Planning Application Ref: BE/64/19/T

Location: Fairmead, Shripney Road, Bognor Regis, PO22 9NZ

Description of works: Crown lift by 4m and reduce height & laterals by 3.5 - 4m to 1no. ash tree

FAIRMHEAD - SHRIPNEY ROAD

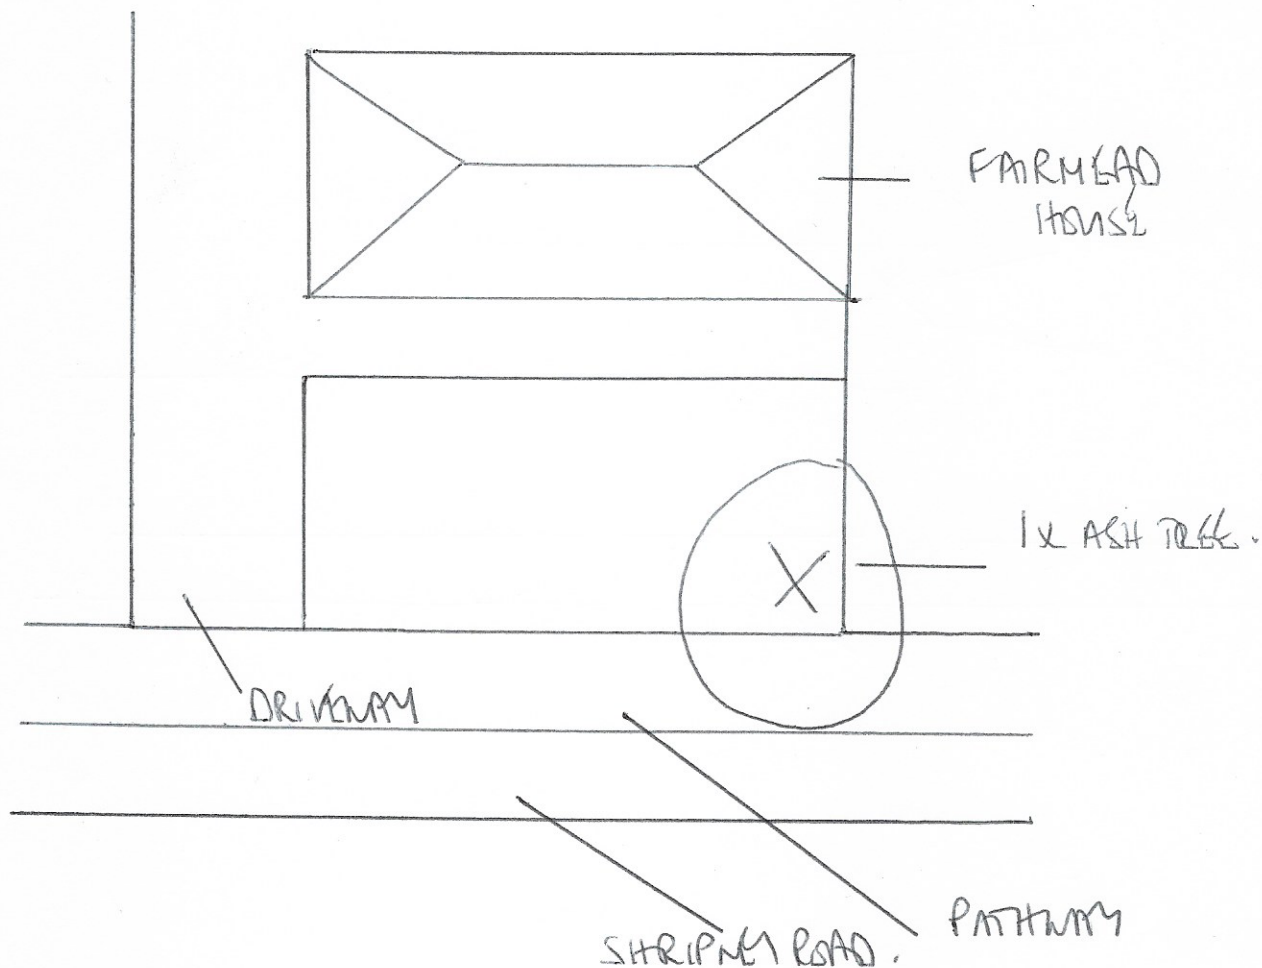
- This is a large tree with a full and relatively unmodified crown. It has a visually attractive profile. Outwardly and from a distance it appears to be in a fine physiological state and structurally sound – a fine example of its type.
- It is a landmark tree both highly visible from adjacent residential properties and to users of the busy public highway (A29). As such, it is of high public amenity value.
- The proposed removal of low branches to achieve 4metres overhead clearance on all aspects is within the tolerance recommended by British Standard 3998:2010 – Tree work.

- The proposal to reduce both the height and lateral spread on all aspects (the correct interpretation of *crown reduction*) by up to 4metres respectively does not comply with 'British Standard (BS3998:2010) Tree work – Recommendations' and would be likely to result in harm to the health and vitality of the tree with large pruning wounds being formed. This has not been justified on arboricultural grounds.
- The tree is a significant feature in the local landscape and appears to be in adequately sound and healthy condition. The tree surgery proposed in the application would result in excessive reduction of the tree's landscape impact and undue detriment to the visual amenities of the locality.

- As it stands, I must recommend **REFUSAL** for this application.

- I would like to see the applicant submit a revised work specification which eliminates the *crown reduction* element, such as detailed below. That would seem to address some of their concerns whilst preventing a diminution of the tree's landscape and public amenity value:

- Remove or reduce carefully selected low branches to achieve no more than 4metres overhead clearance on all aspects.
